WEST SUSSEX COUNTY COUNCIL CONSULTATION

TO:	Arun District Council FAO: Anita Gardner
FROM:	WSCC - Highways Authority
DATE:	17 June 2020
LOCATION:	6 Manor Road Littlehampton BN16 3QT
SUBJECT:	R/92/20/PL Demolition of existing garage & store on existing dwelling & erection of 2No detached bungalows to rear.
DATE OF SITE VISIT:	n/a
RECOMMENDATION:	More Information
S106 CONTRIBUTION TOTAL:	n/a

BLOCK PLAN: 6 MANOR ROAD, RUSTINGTON.

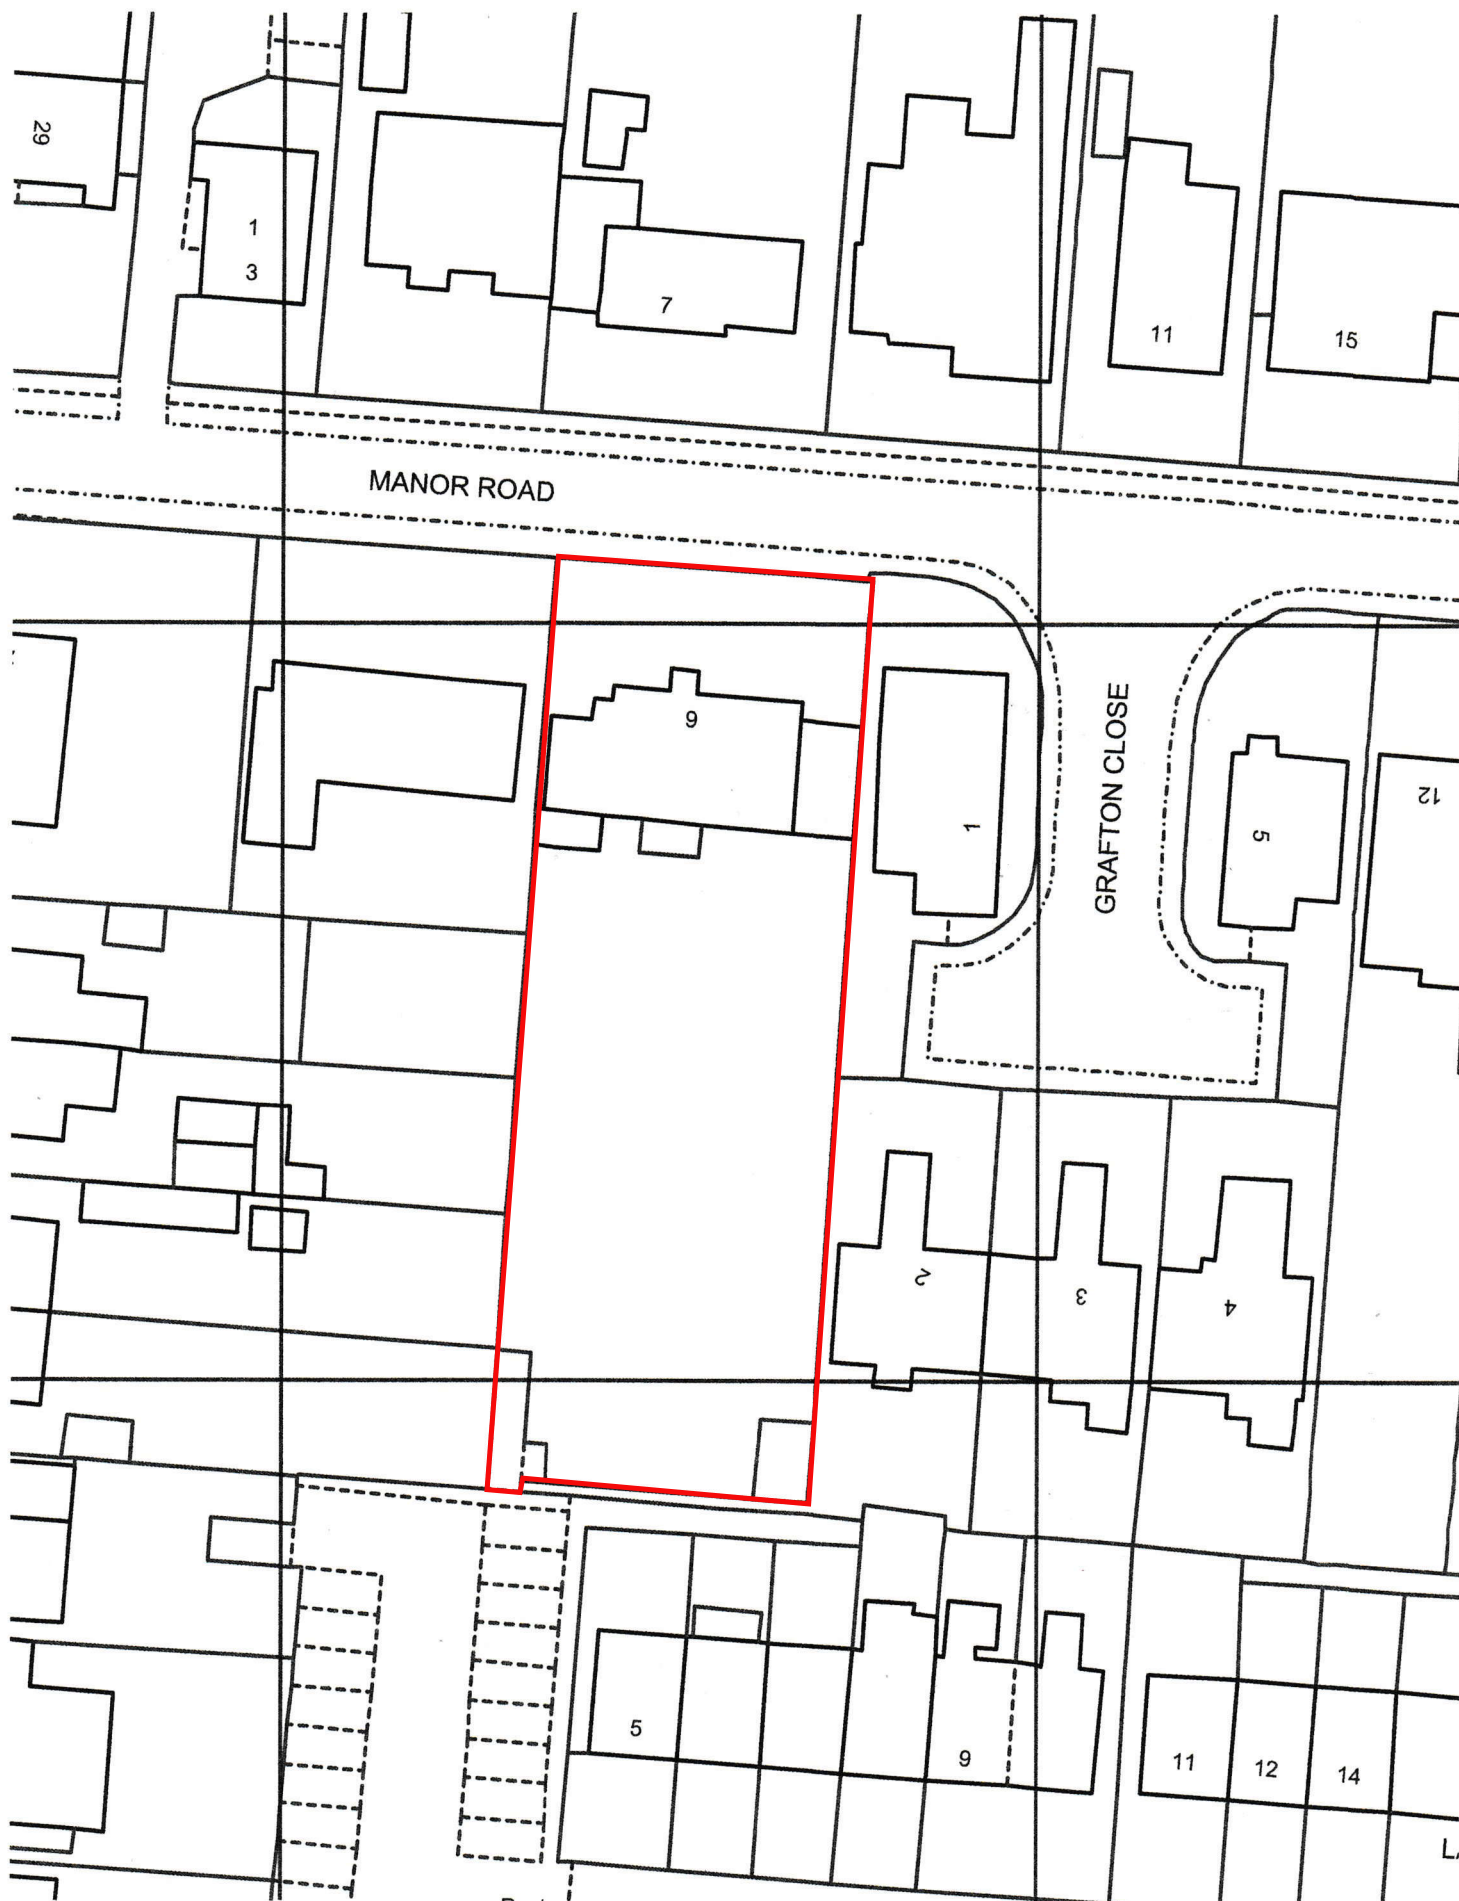
The plans demonstrate the red edge highlighting part of the publicly maintainable highway to be included within the proposed works. The LHA asks, what work is proposed within this area?

REVISED SITE PLAN CHANGES:

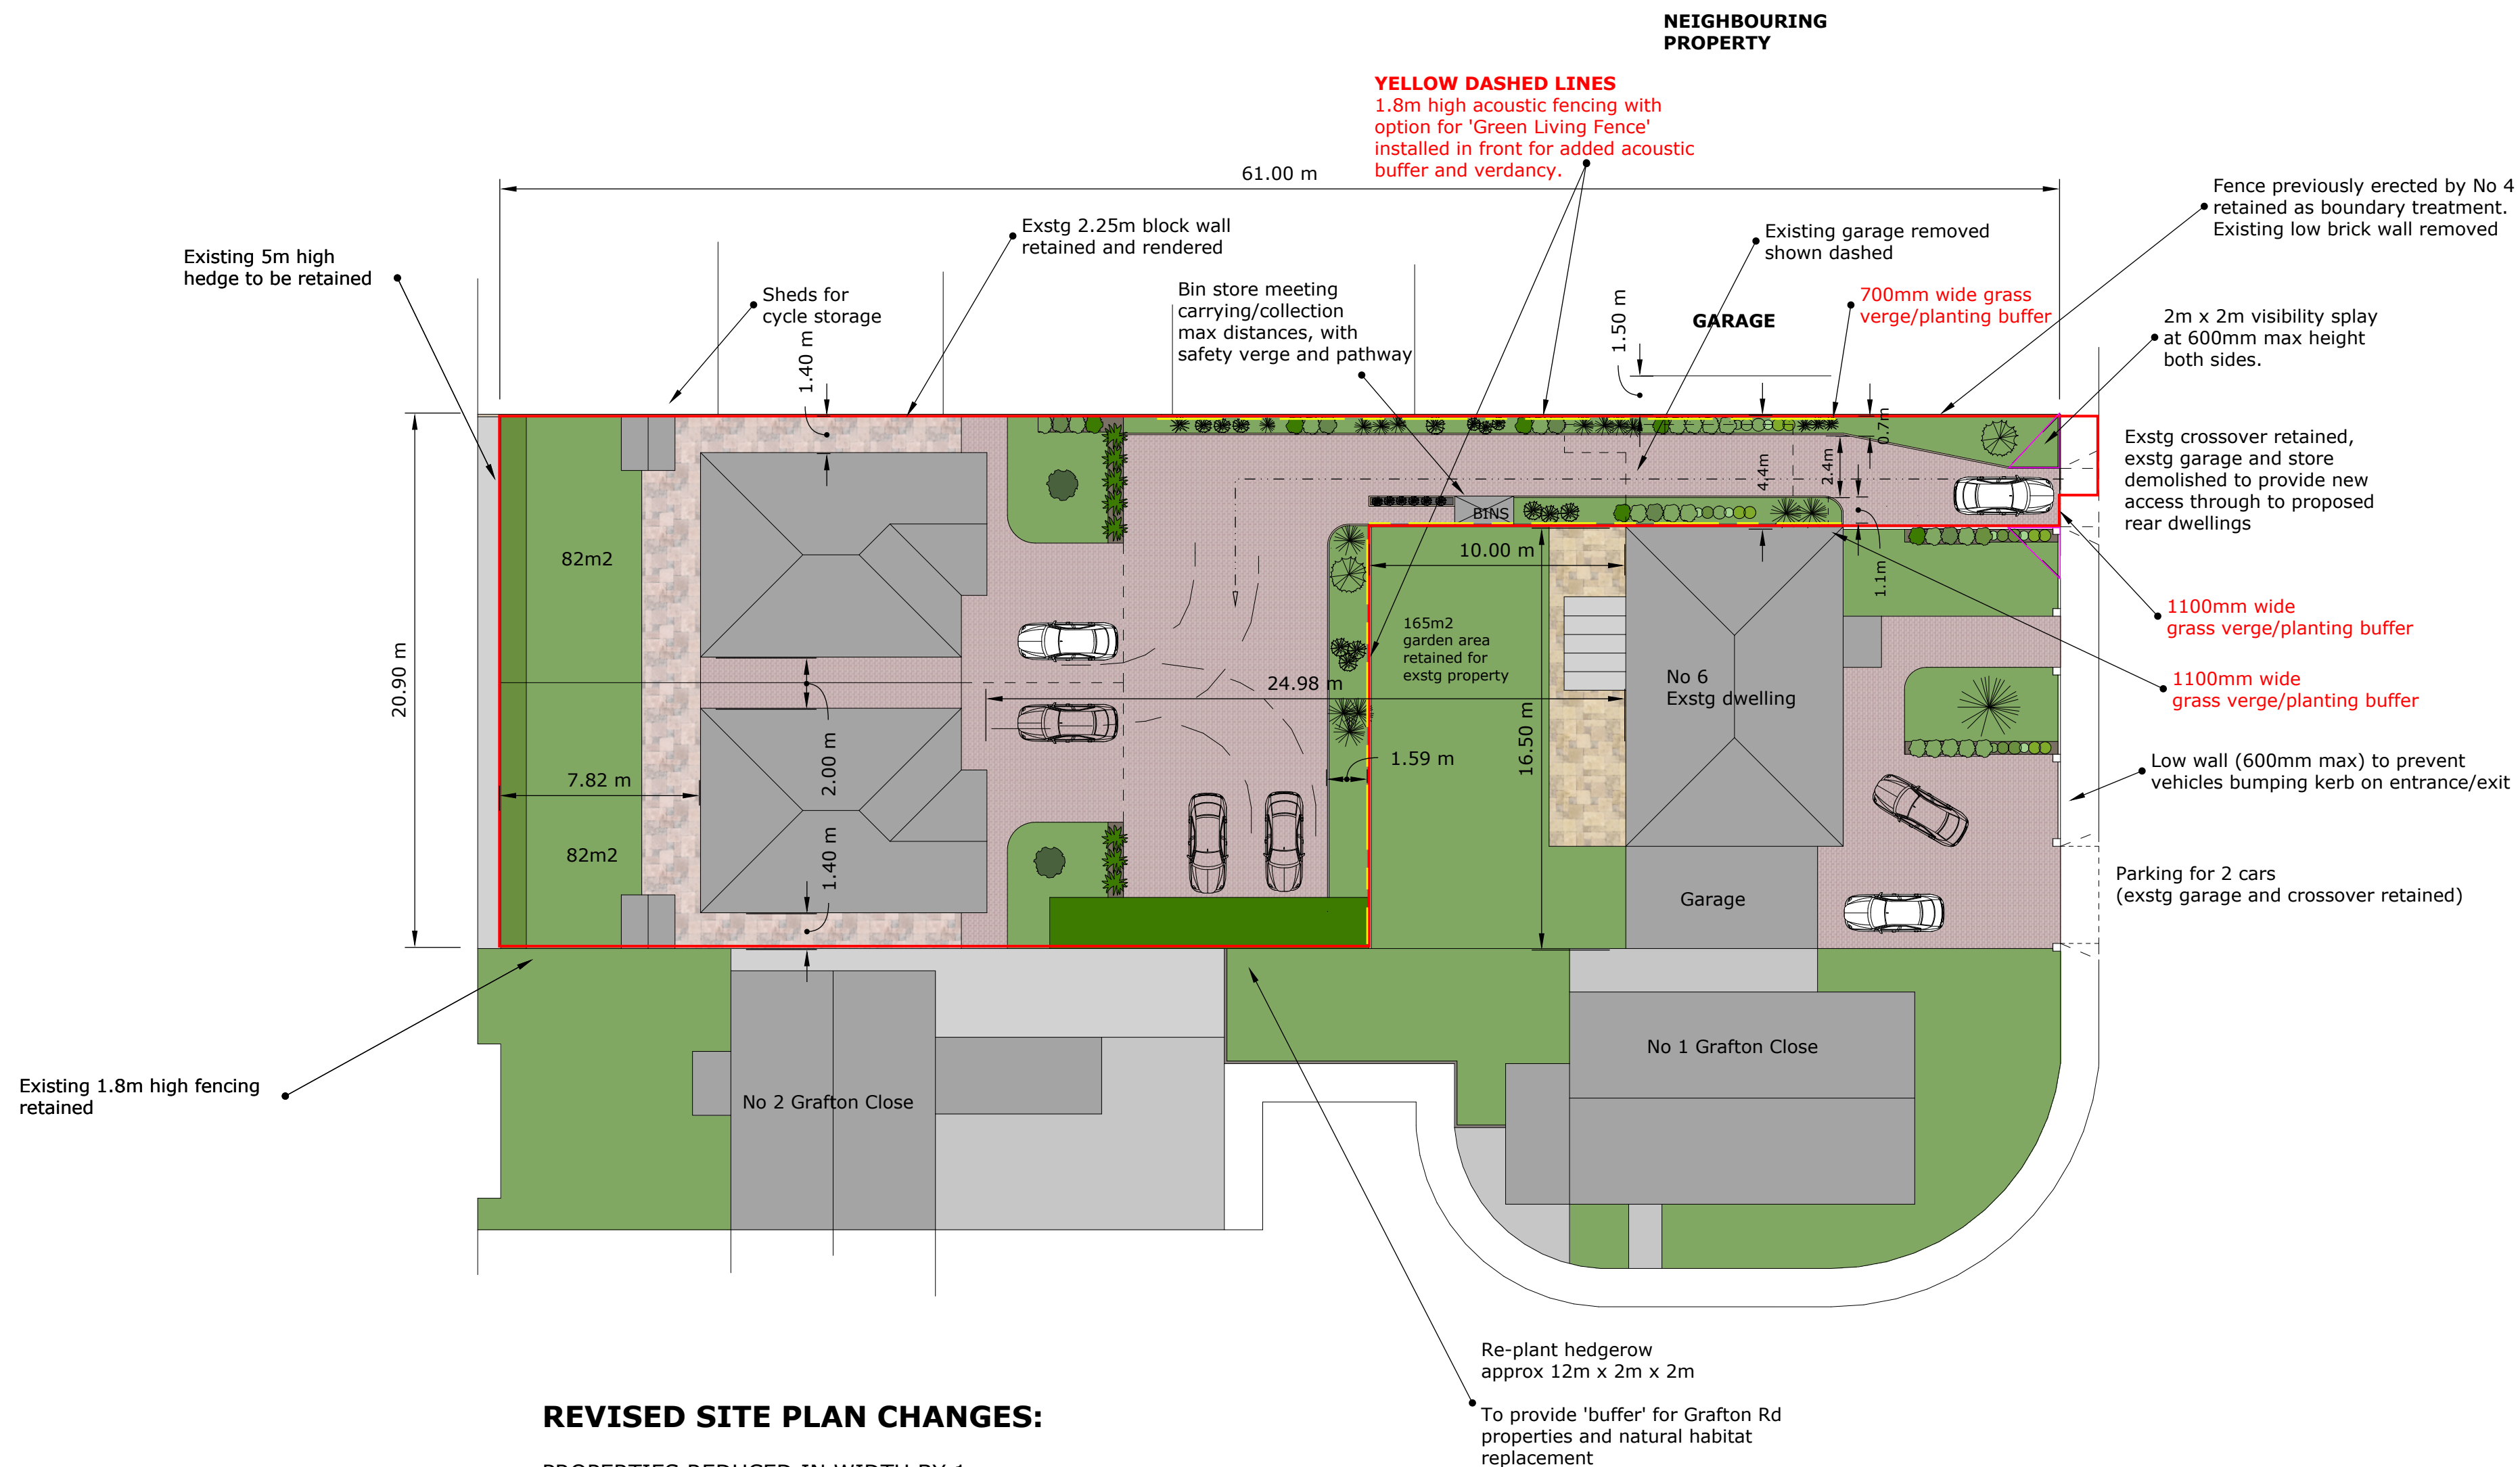
The applicant has not included the new parking area proposed for the existing dwelling. The LHA asks is this subject to the current planning application?
